From: Simon Davis
Sent: 26 November 2018 12:06
To: 'Chris Moore'
Subject: FW: FP/232/18/PL Snooks Corner

SITE PLAN - 1/500

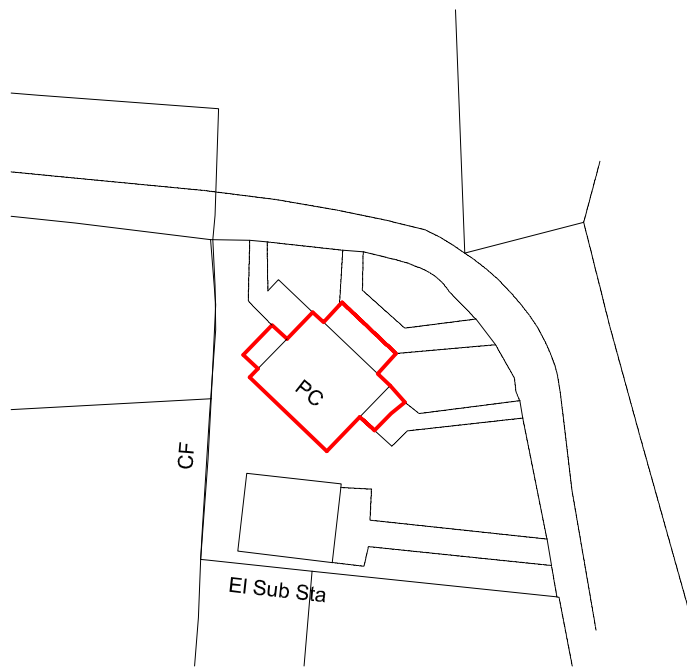
Please see emails below containing additional questions about the use. I am also interested in the servicing arrangements as the red edge does not include any parking spaces and the site is fronted by double yellow lining. Can you provide a further response to me.

Shame this wasn't made clear in the application. I guess my concerns would relate to how deliveries and collections would be made with this building set back off the highway and located on an acute corner. There is also not a drop kerb (only for wheelchair access and it is not clear whether an access means will be created.
